**From:** [Jeremiah Cromie](#)  
**To:** ["Dustin Pierce, PLS"](#)  
**Cc:** ["broseburg@hotmail.com"](mailto:broseburg@hotmail.com)  
**Subject:** RE: BL-21-00013 Roseburg Request for Location of Well and Drainfield near house site  
**Date:** Tuesday, June 22, 2021 2:42:00 PM

**From:** Jeremiah Cromie  
**Sent:** Tuesday, June 8, 2021 4:34 PM  
**To:** 'Dustin Pierce, PLS' <[dpierce@encompasses.net](mailto:dpierce@encompasses.net)>  
**Subject:** BL-21-00013 Roseburg Request for Location of Well and Drainfield near house site

**RECORD OF SURVEY**  
 A PORTION OF THE NE 1/4 OF SECTION 3 AND  
 A PORTION OF THE NW 1/4 OF SECTION 2  
 TOWNSHIP 19 NORTH, RANGE 15 EAST, W.M.,  
 KITTITAS COUNTY, WASHINGTON

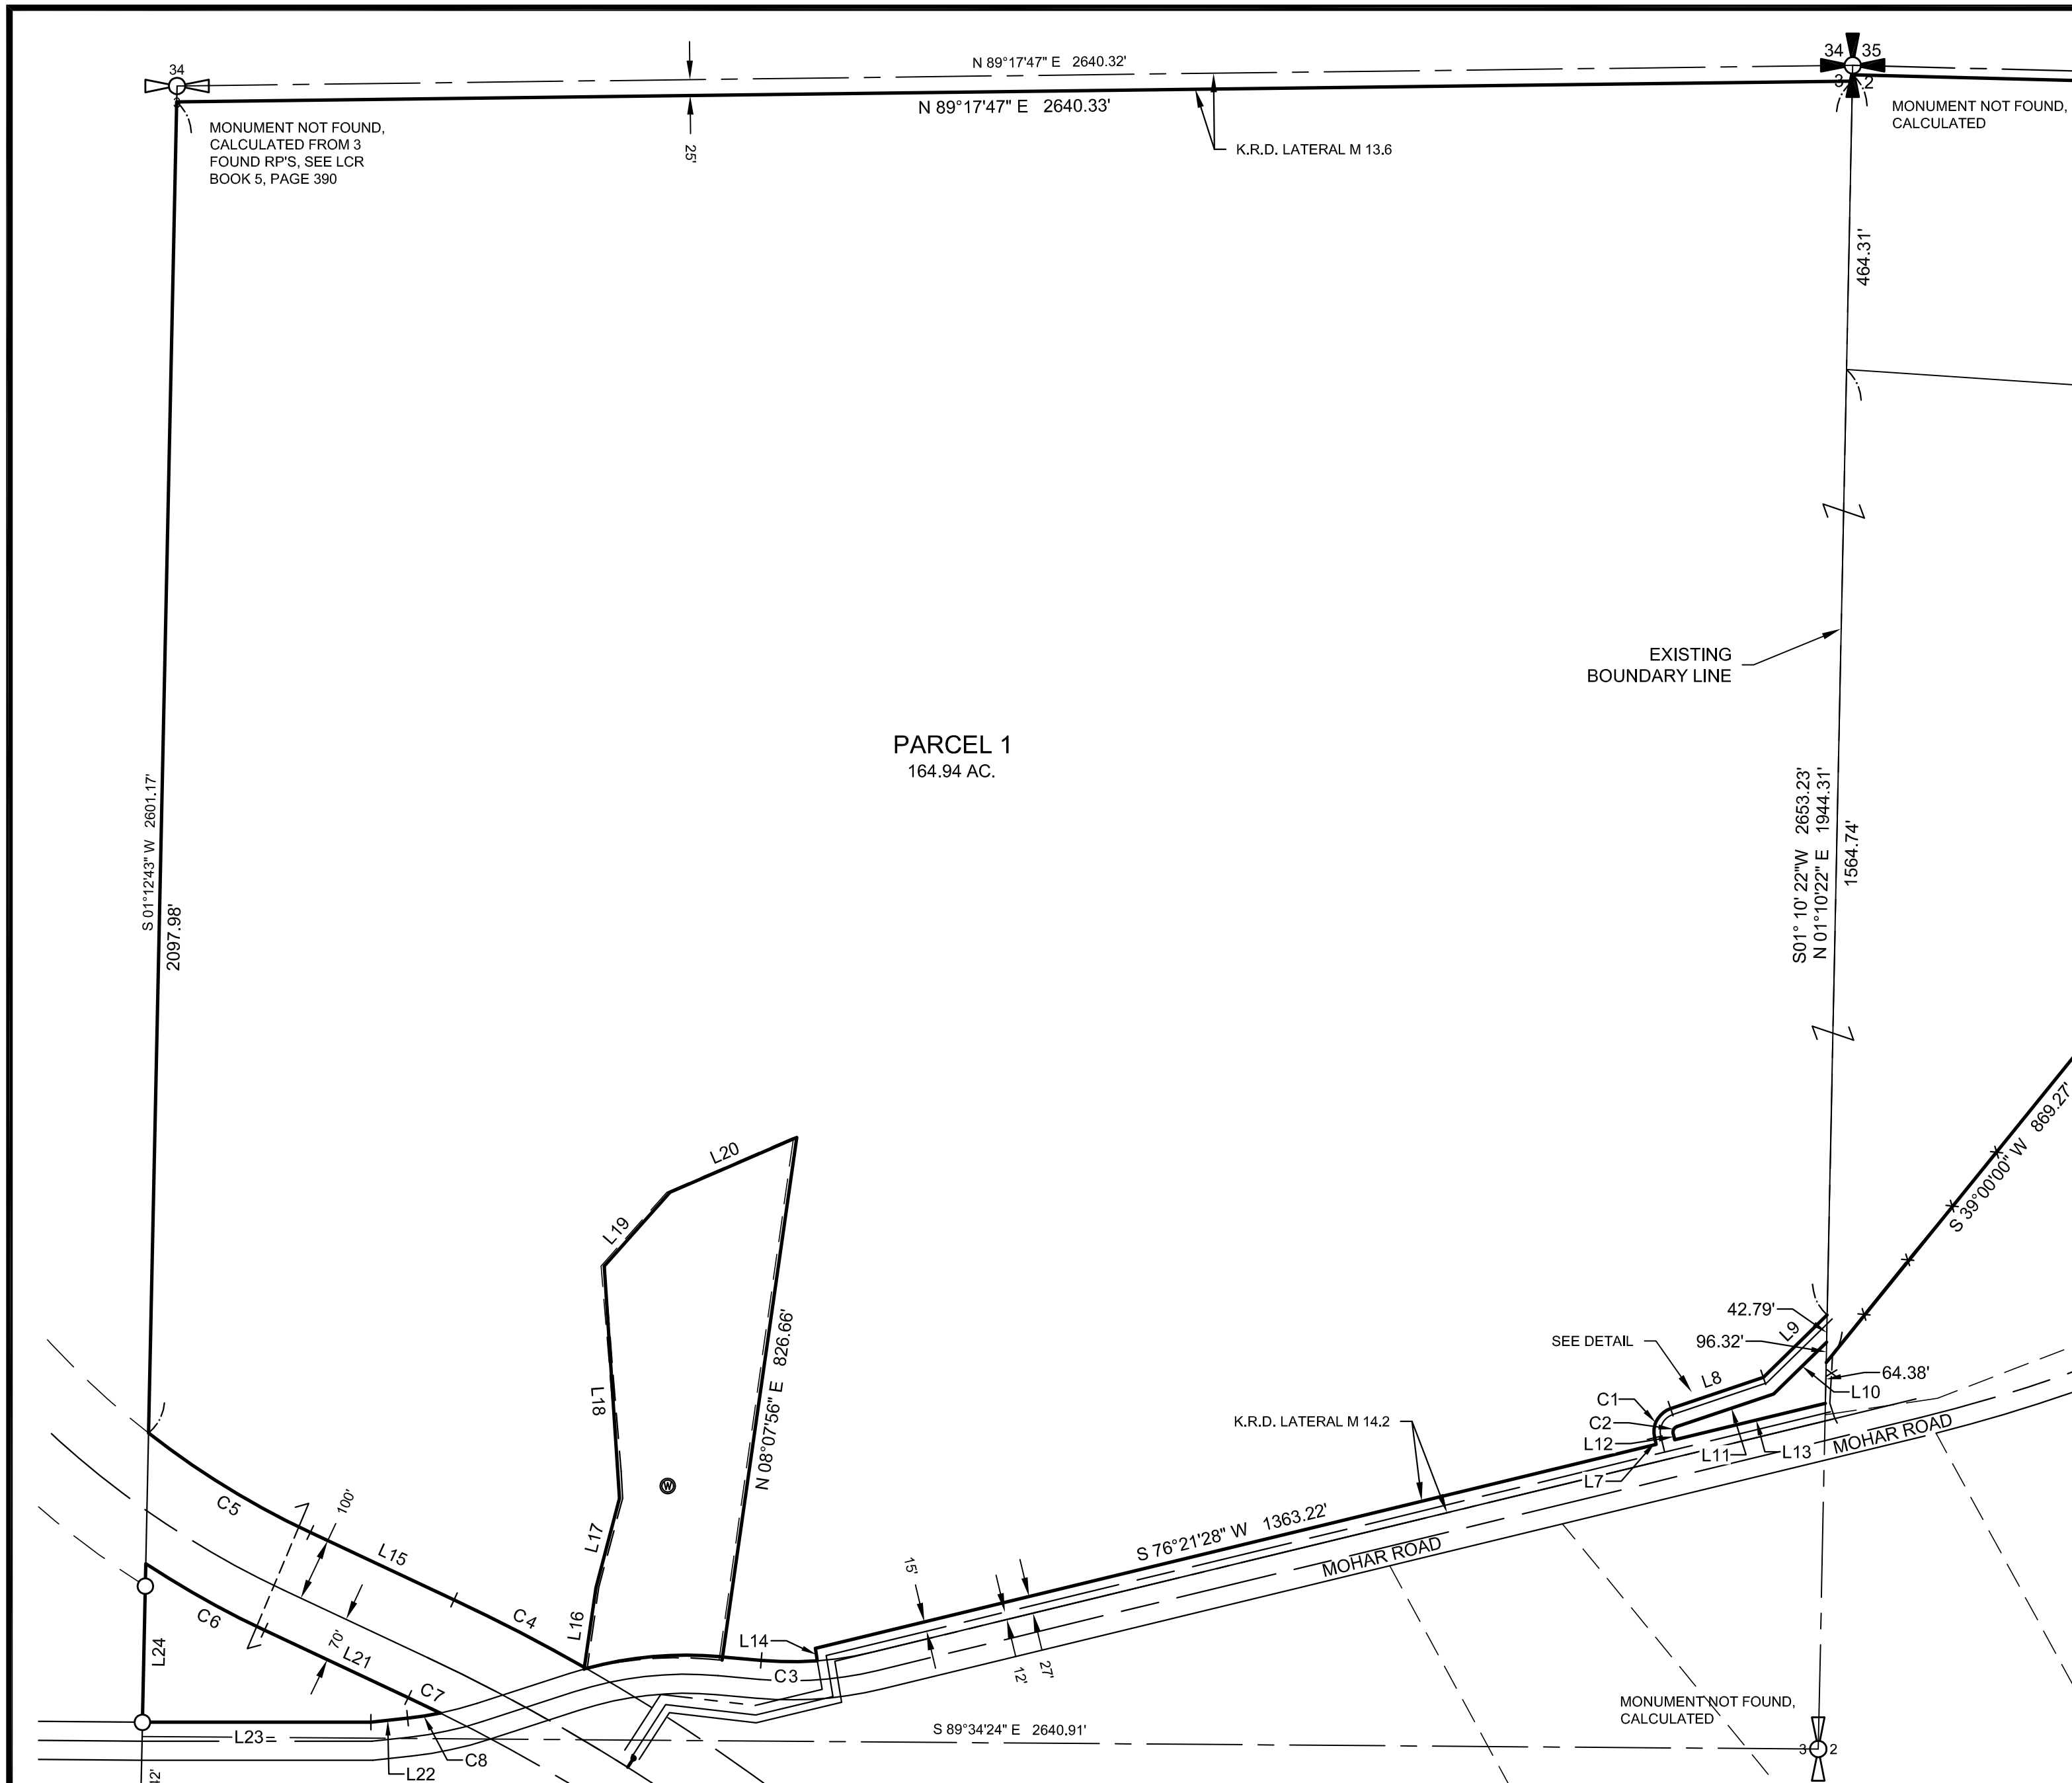
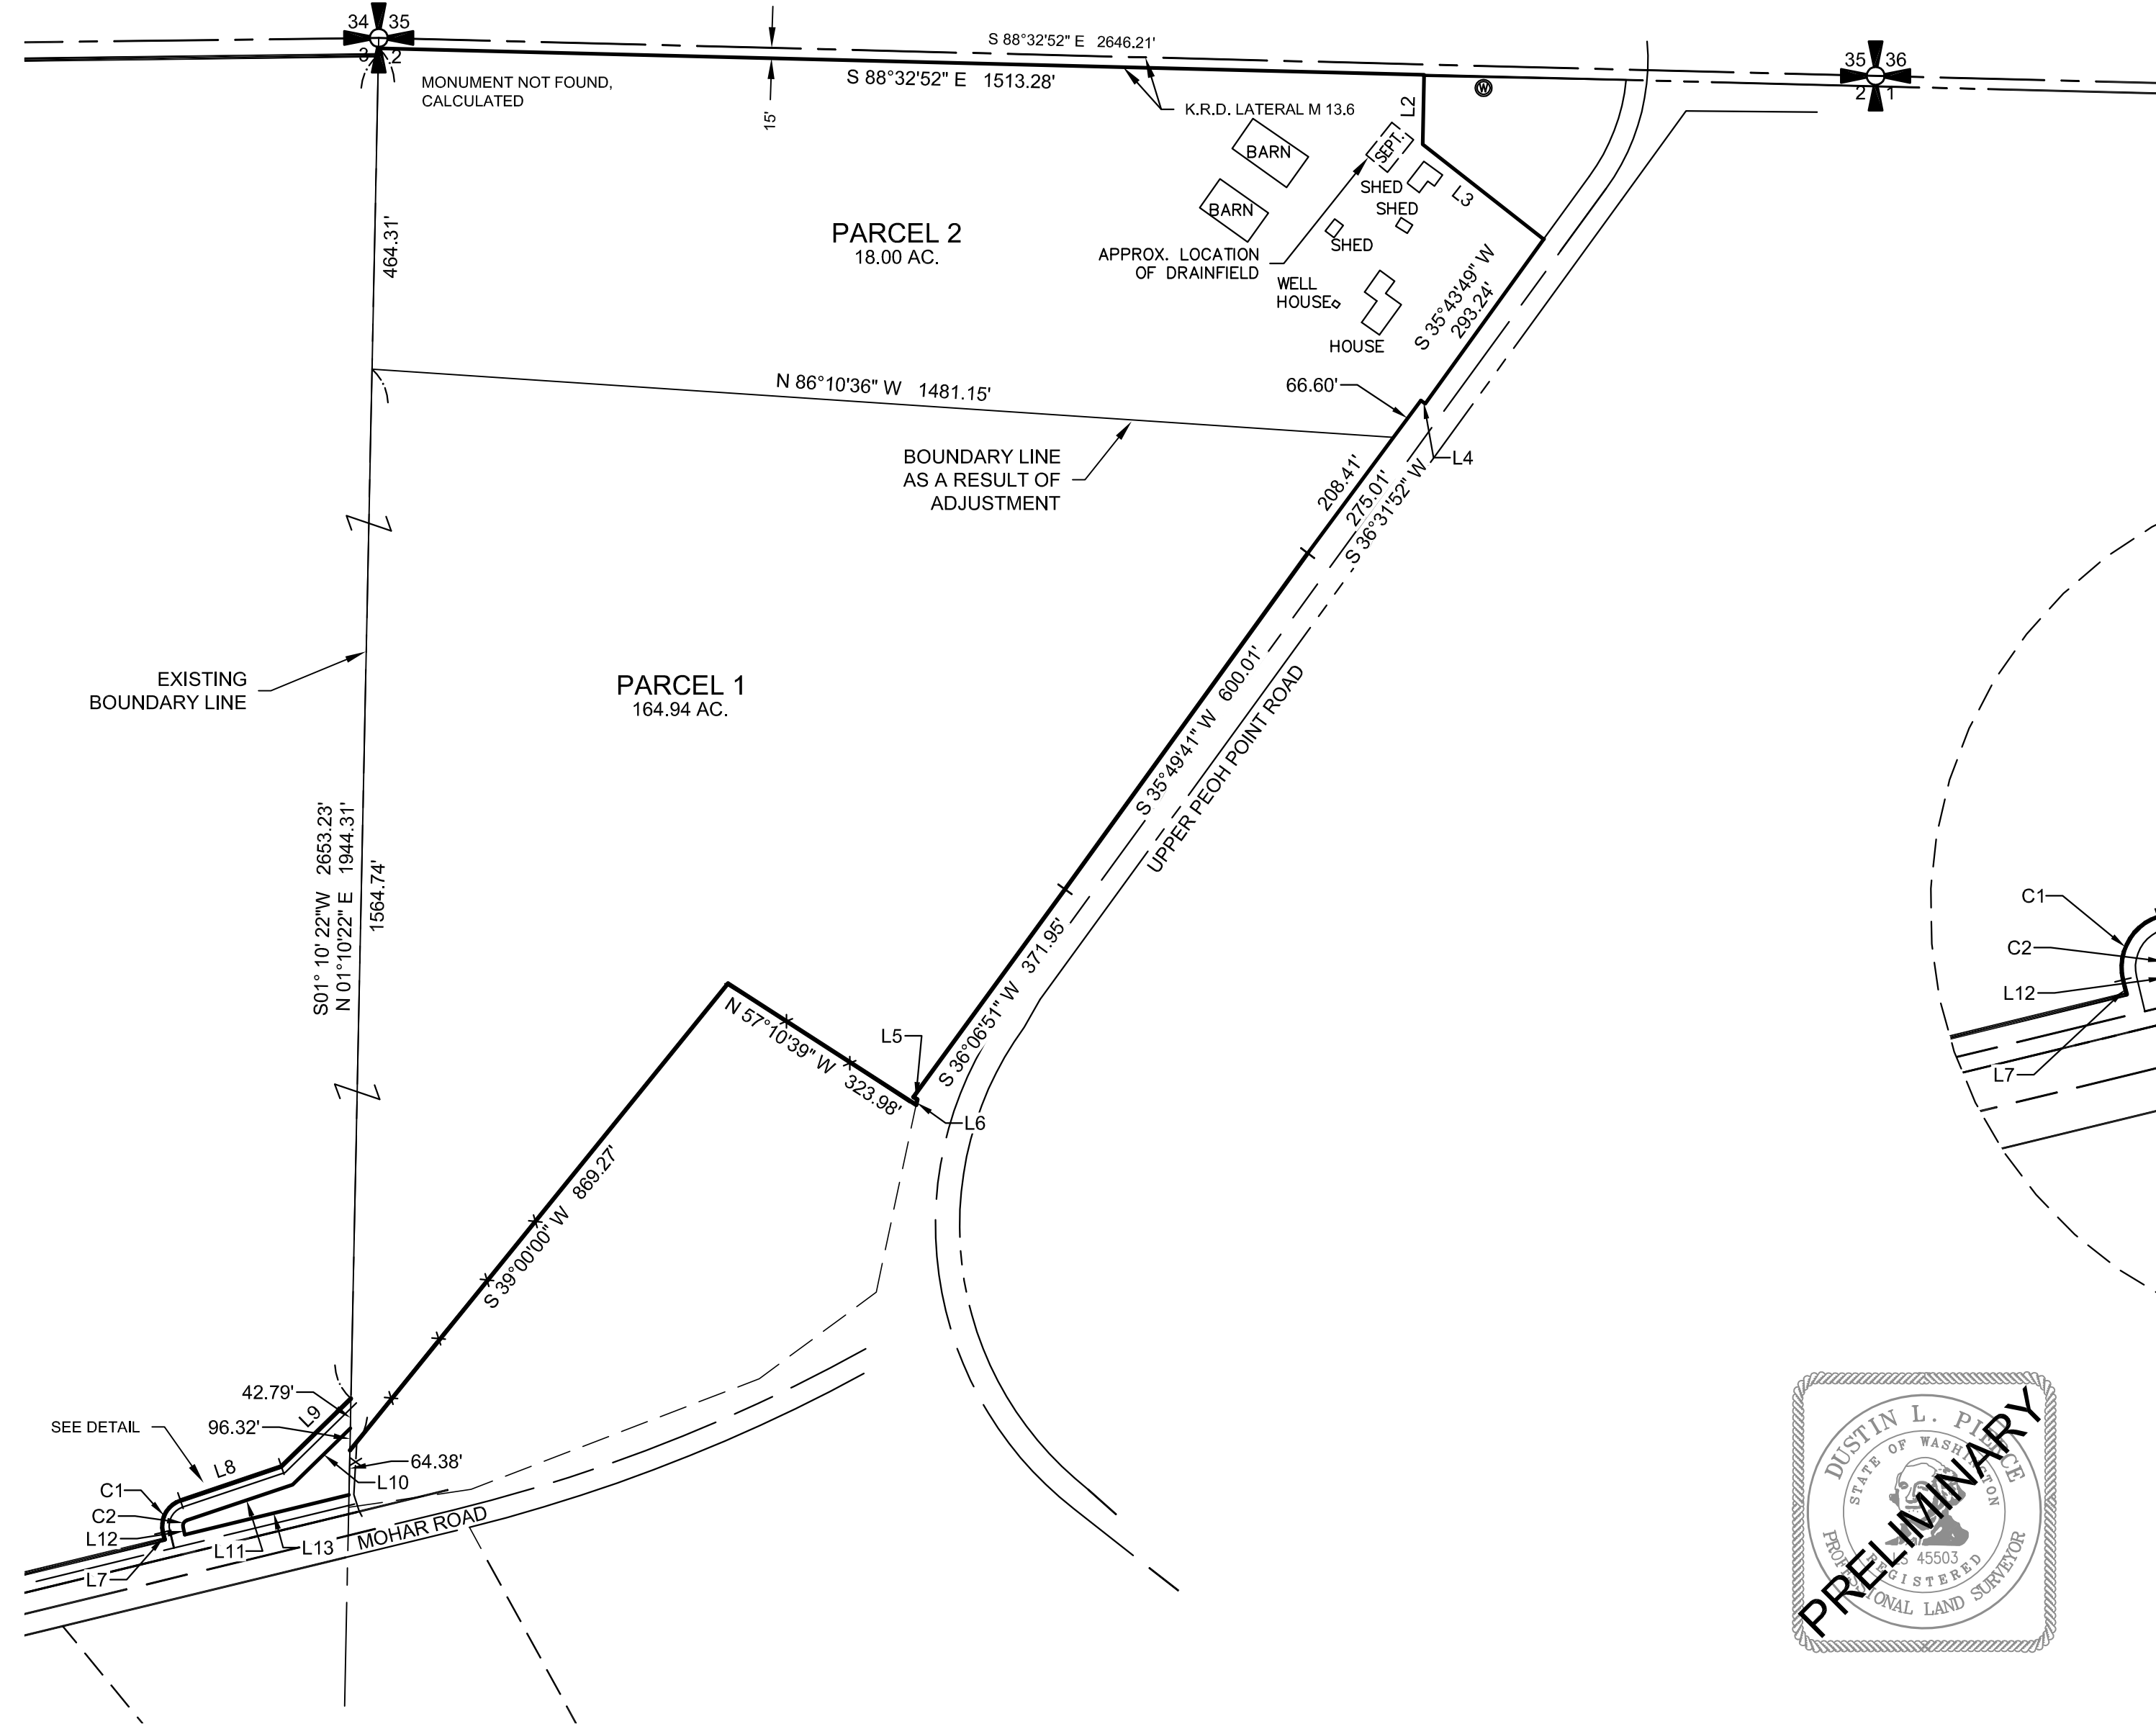
I still have not seen any site plan/survey that shows the well and drain field. Bill mentioned that someone had dropped those off last week but I asked around and nobody said anything had come in related to it. Did you drop them off with someone? You can just e-mail the updated plans and that would work fine also.
